STATE OF NORTH CAROLINA
DEPARTMENT OF TRANSPORTATION

Subject: **Application for the Modification to the Section 404 Individual Permit and Section 401 Water Quality Certification** for US 501 from NC 49 in Roxboro to SR 1602 (Jesse Banks Road) in Person County, Division 5. Federal Aid Project No. STP-501(11), WBS Element No. 34406.2.3, TIP No. R-2241A.

Reference: Section 404 Individual Permit, issued June 6, 2012 USACE Action ID 2009-00439
Section 401 Individual Water Quality Certification, April 5, 2012, NCDENR-DWQ
Water Quality Certification Project No. 20120073

This permit modification request is for revisions to the permit drawings and plan sheets and additional impacts to streams for items that were accidentally left off the drawings from previous meetings and a revision to Utility Site 1. Included with the permit modification is this cover letter, revised Stormwater management plan and revised permit drawings 3, 3a, 4, 5, 16, 17, 27, 28, 35, 36, 37, 38, 39, 40, 45, 46, 47, 48 of 48, revised Utility Site 1 drawings and revised plan sheets 4, 8, 15, 19, 20 and 22.

REVISED 7/6/2012 ADD GAS MAIN

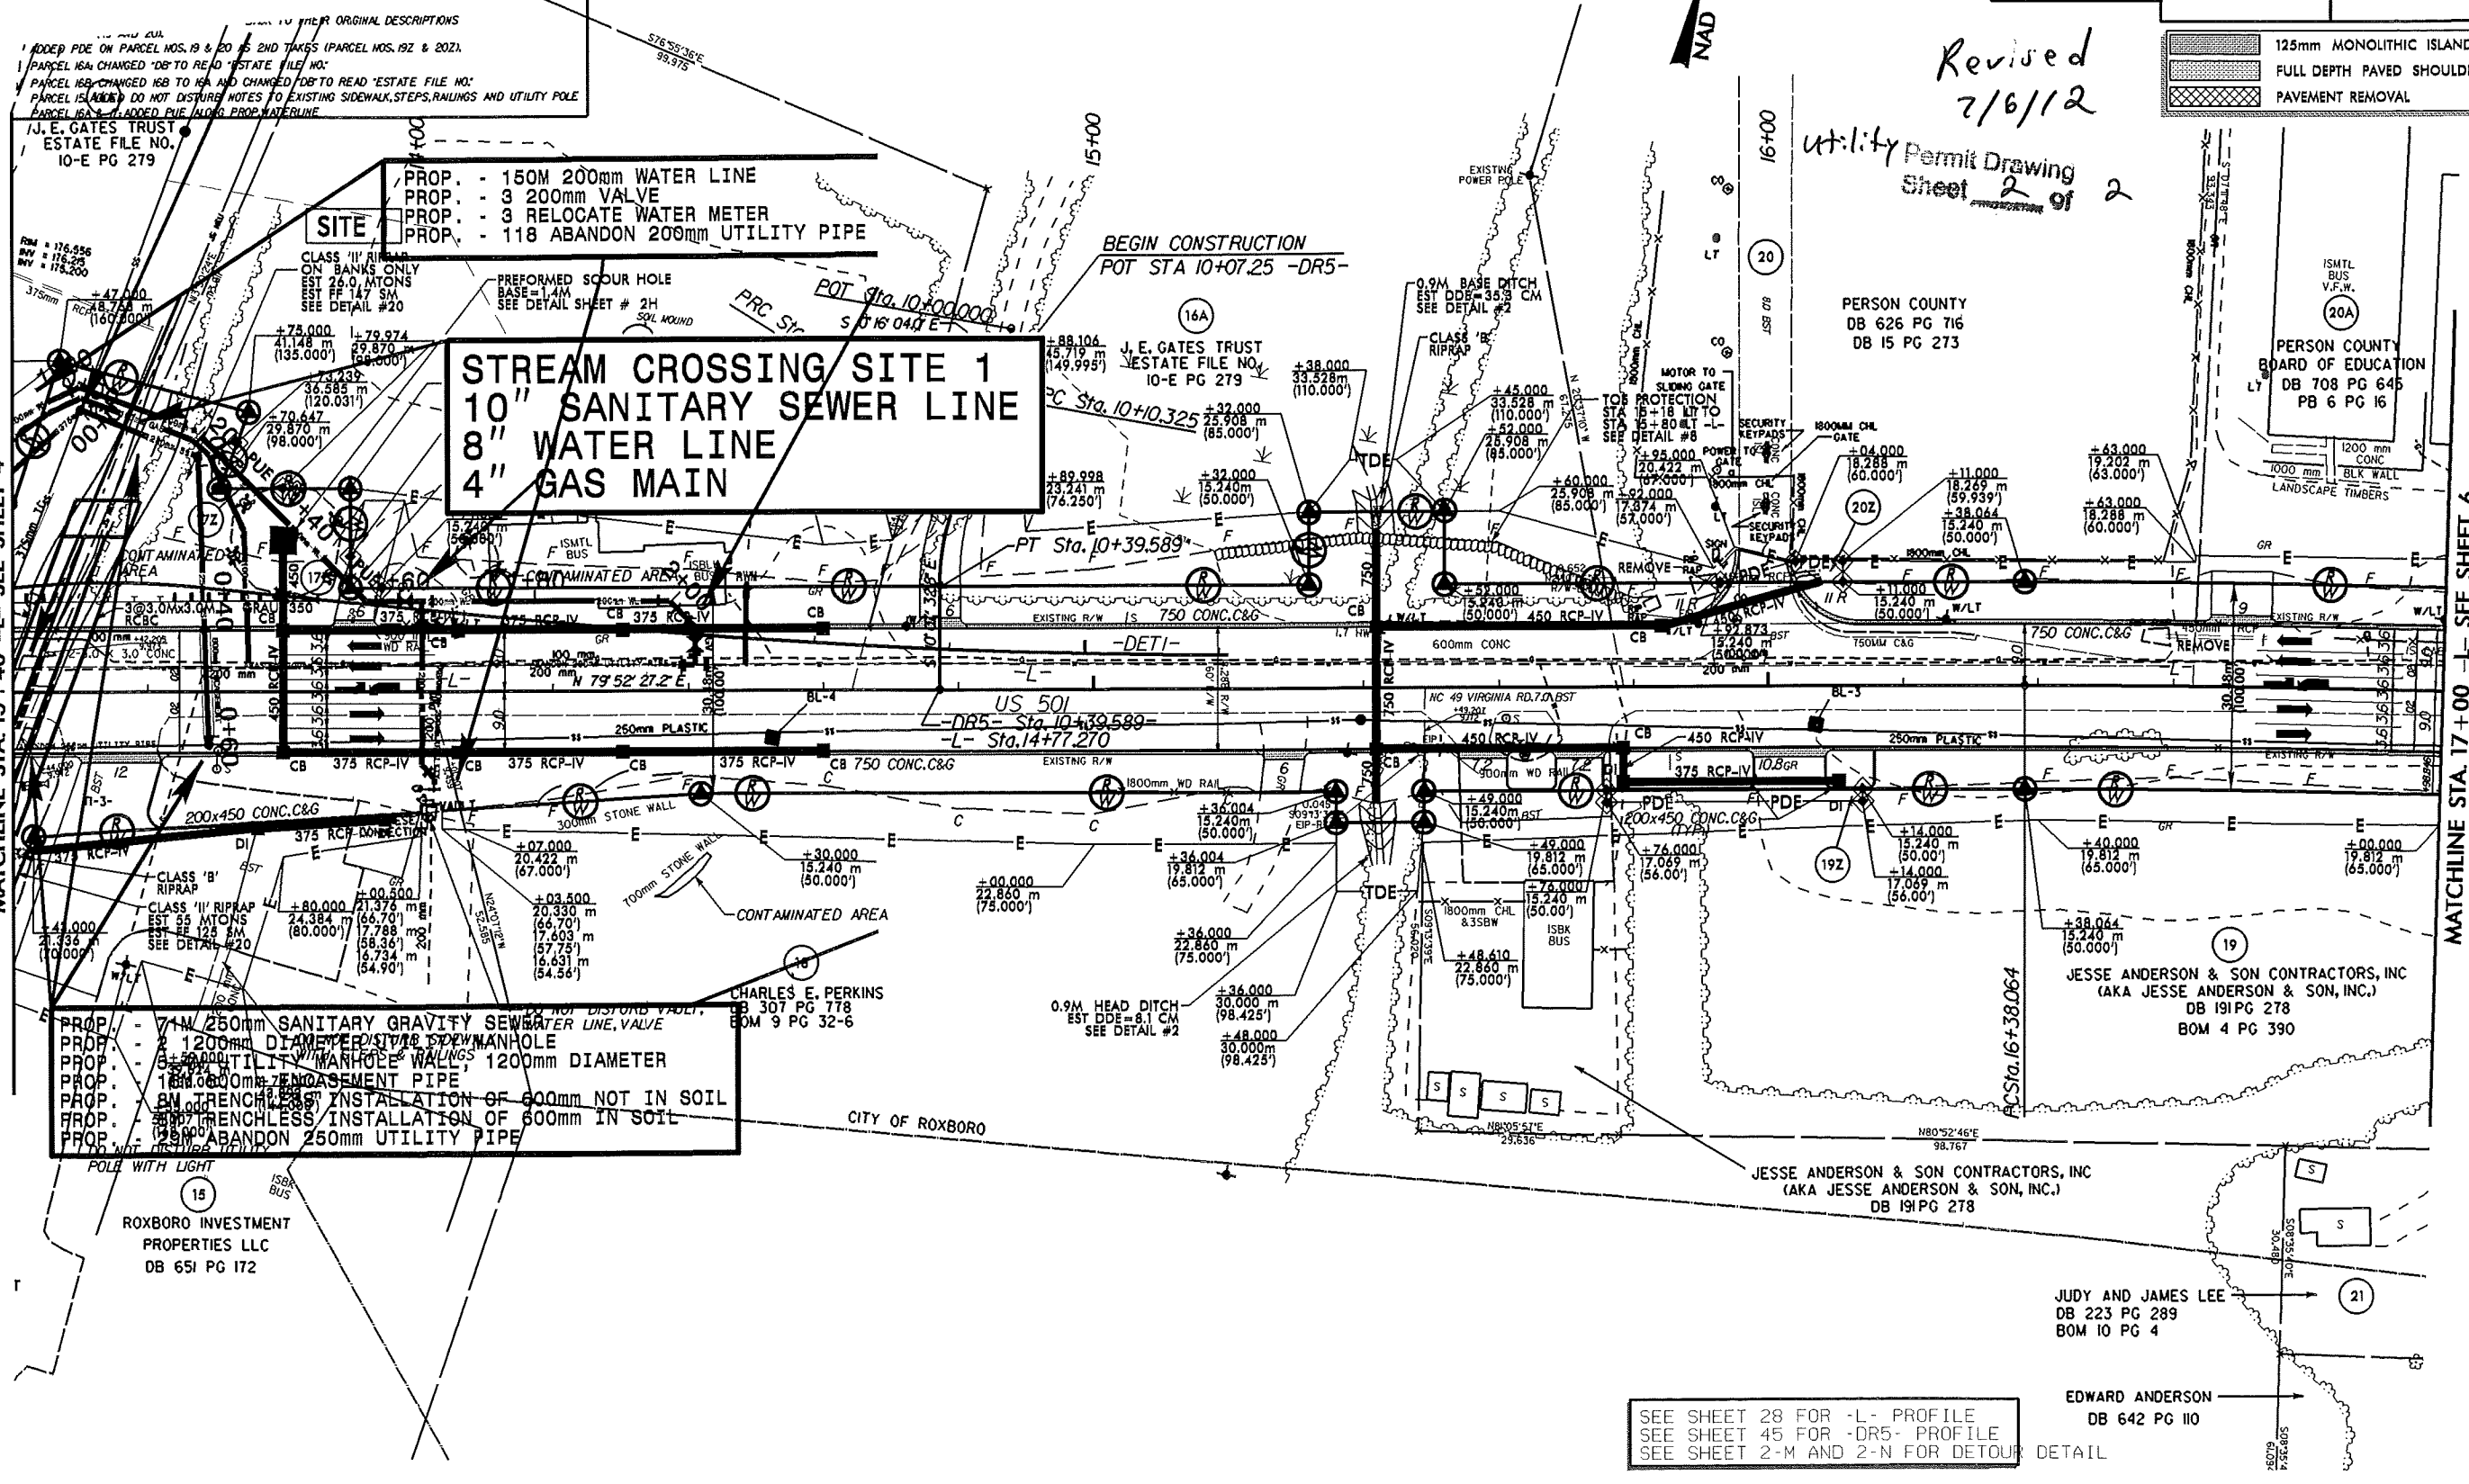
Utility Site 1, Permit Drawings 1 and 2 of 2 (Plan Sheet 5)

-Due to the phasing of the culvert at this site the gas main needs to be relocated for constructability issues. The gas main will be put between the water and sewer lines and all three will be constructed at the same time. The gas main will increase the temporary stream impacts at this site by 2 feet.
